From: Fiona Fitzgerald
Sent: 17 July 2017 13:55
To: Planning.Responses
Cc: Simon Davis
Subject: Y/15/17/DOC

Landscape Plan

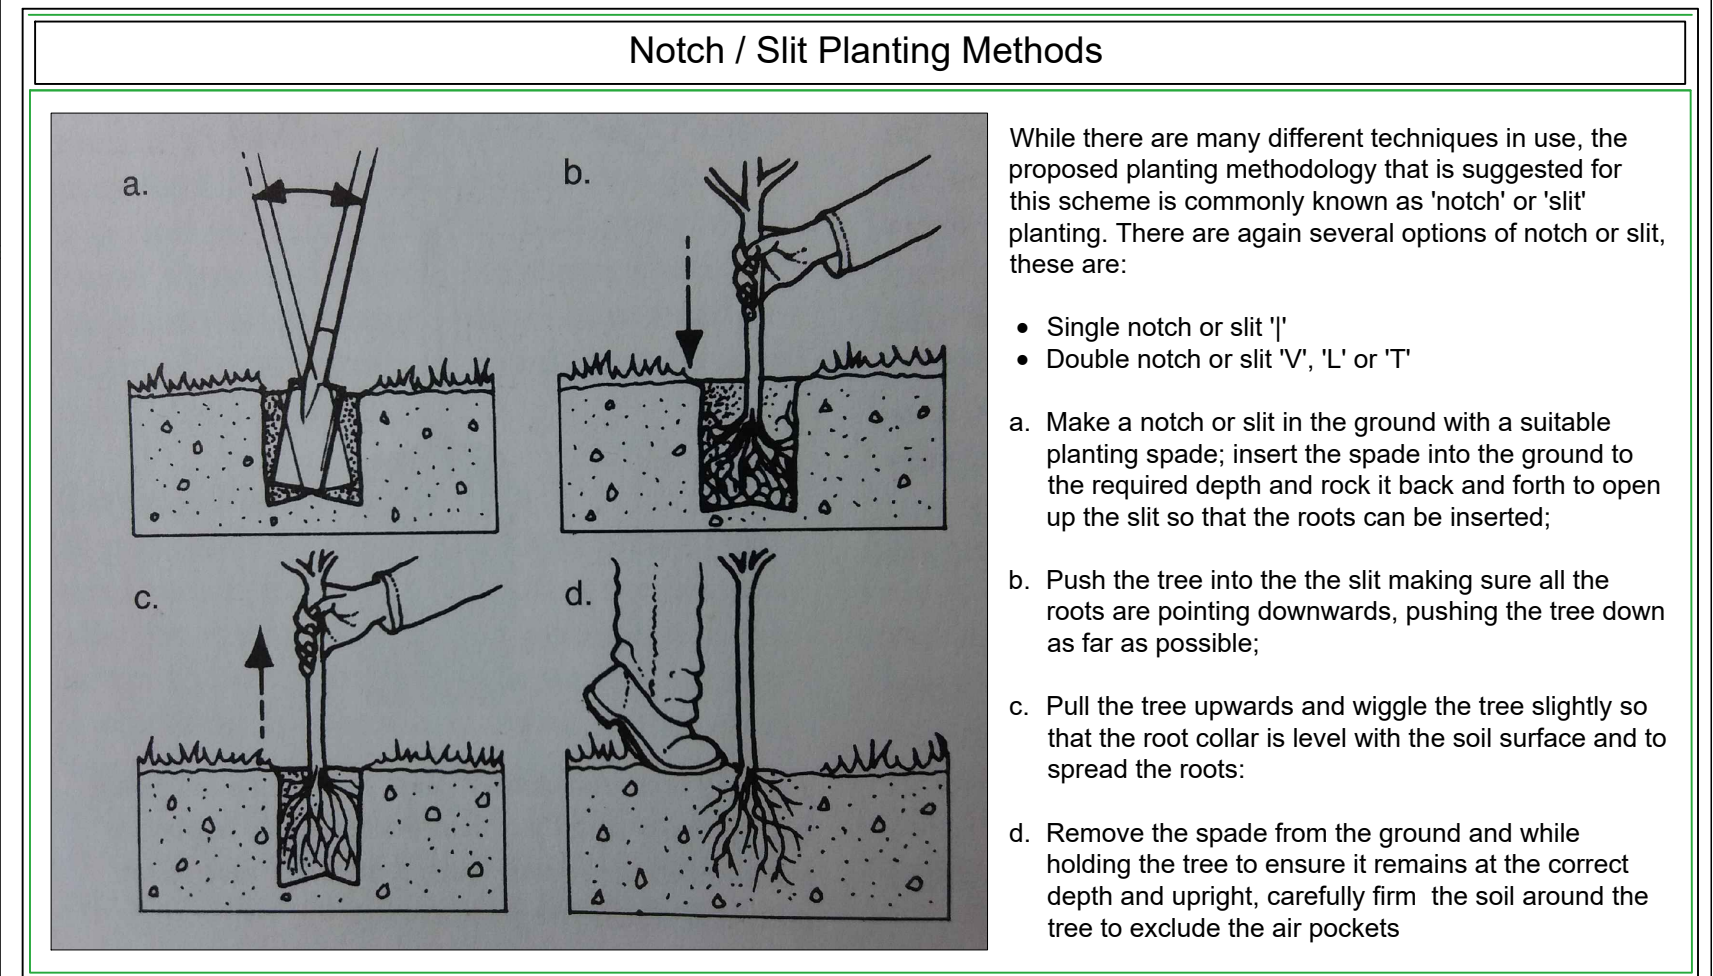
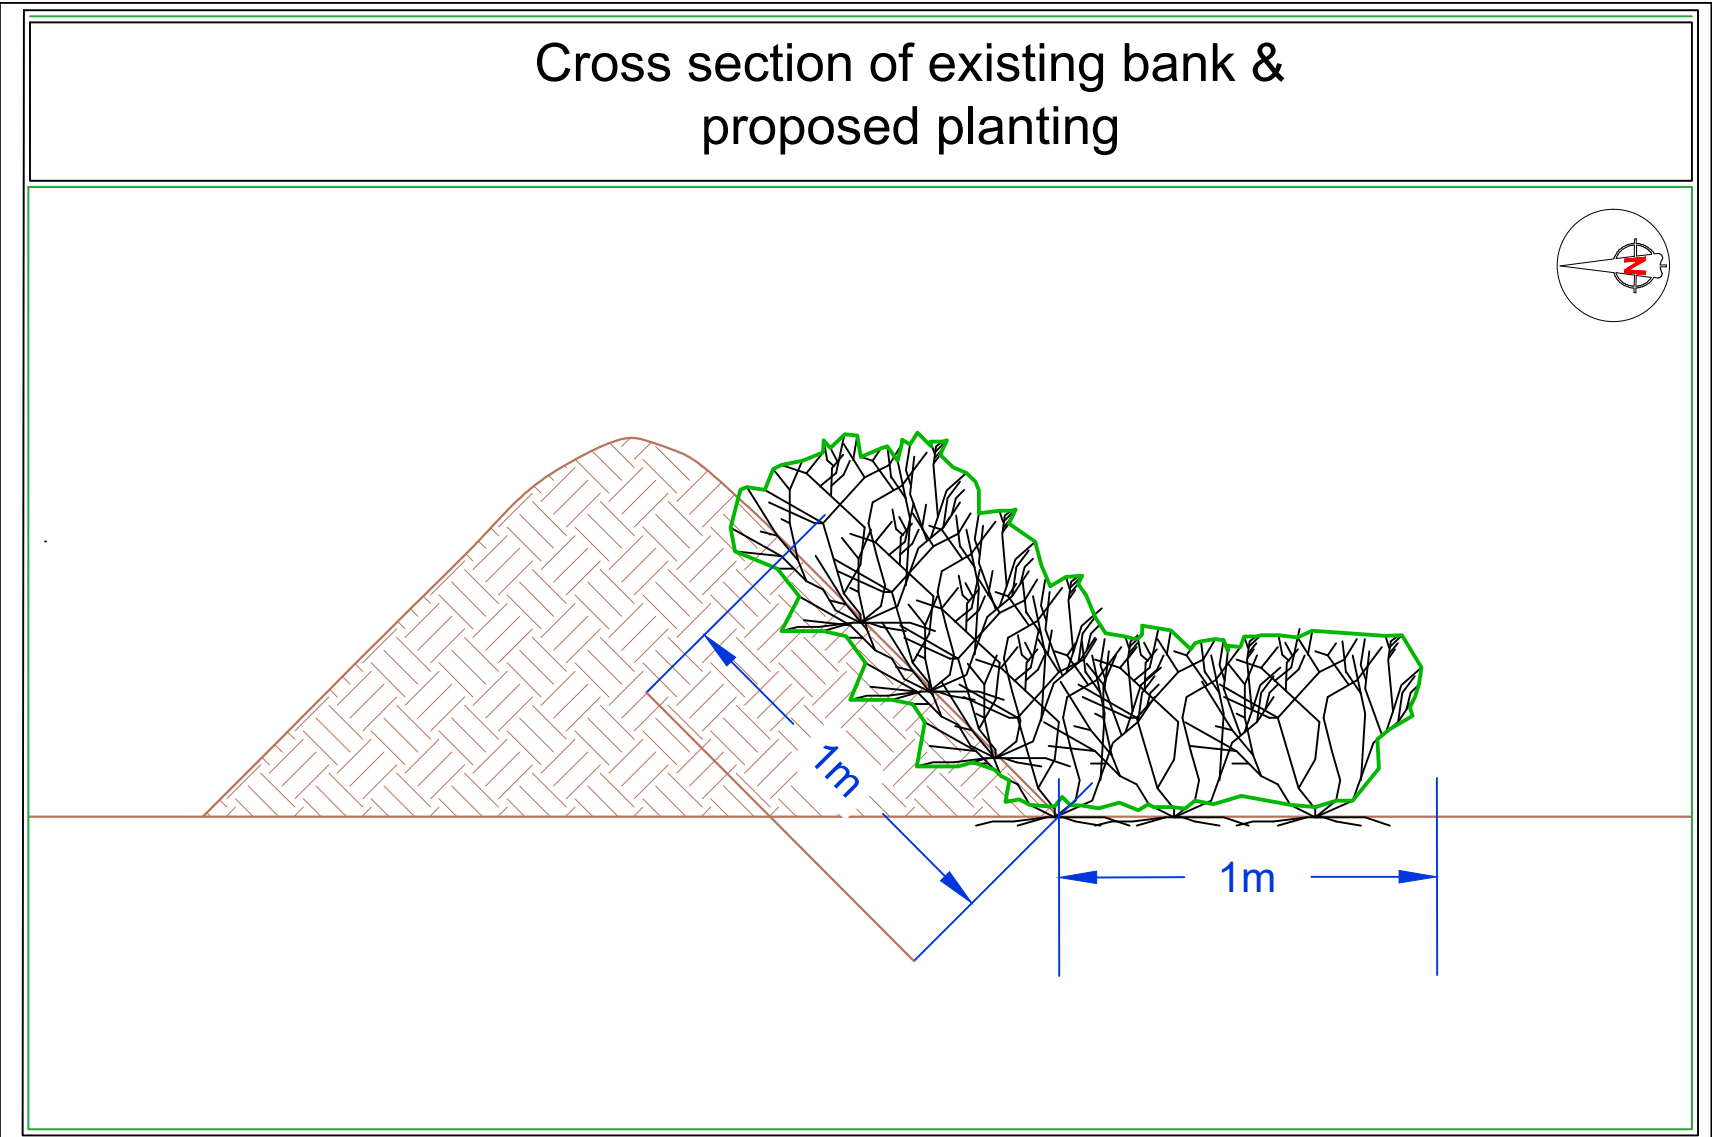
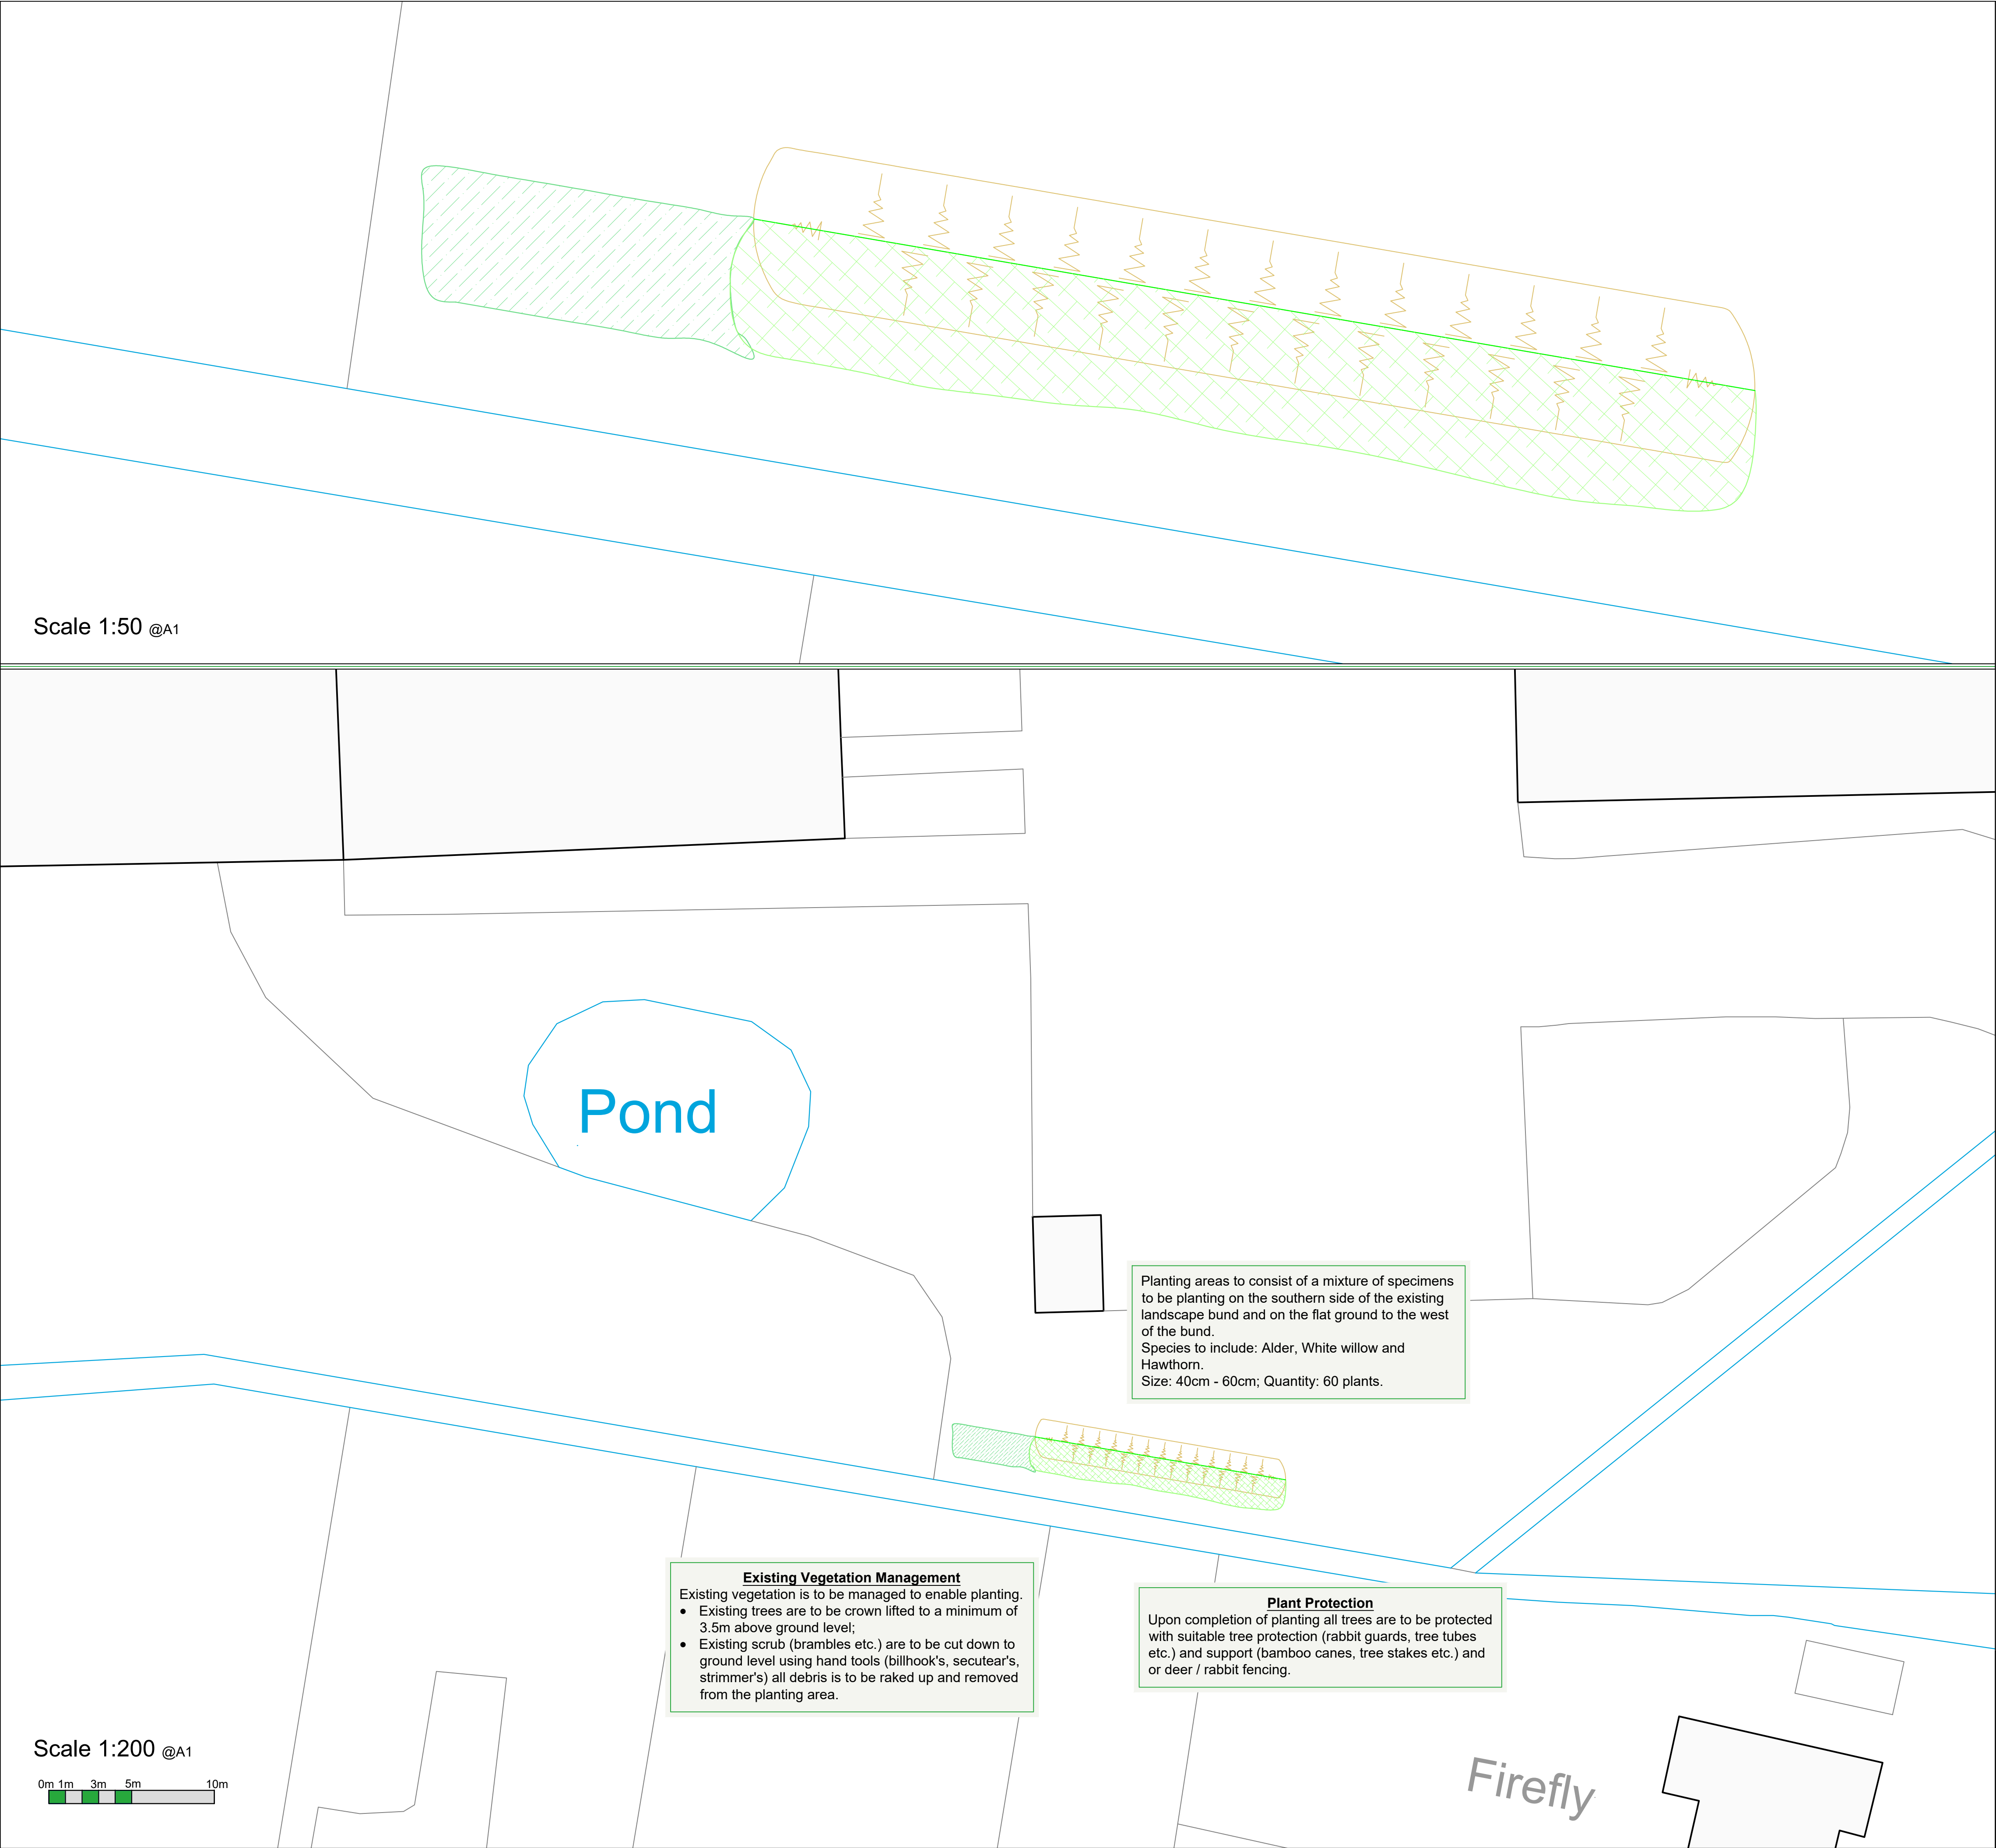
Condition 6 – I would comment that enhancing the original planting along the southern boundary of the Consolidation Centre in order to provide additional mitigation is **not** likely to be effective. Although planting of trees and shrubs may reduce the perception of noise by creating a visual barrier, published results on the effectiveness of tree and shrub barriers indicate that in some cases, noise can be reduced by 6dB over a distance of 30m where planting is particularly dense. This is not the case in this situation as this depth of planting is not being proposed. Environmental Health have no comments on the discharge of this condition beyond stating that it is very unlikely that this will provide any additional noise mitigation.
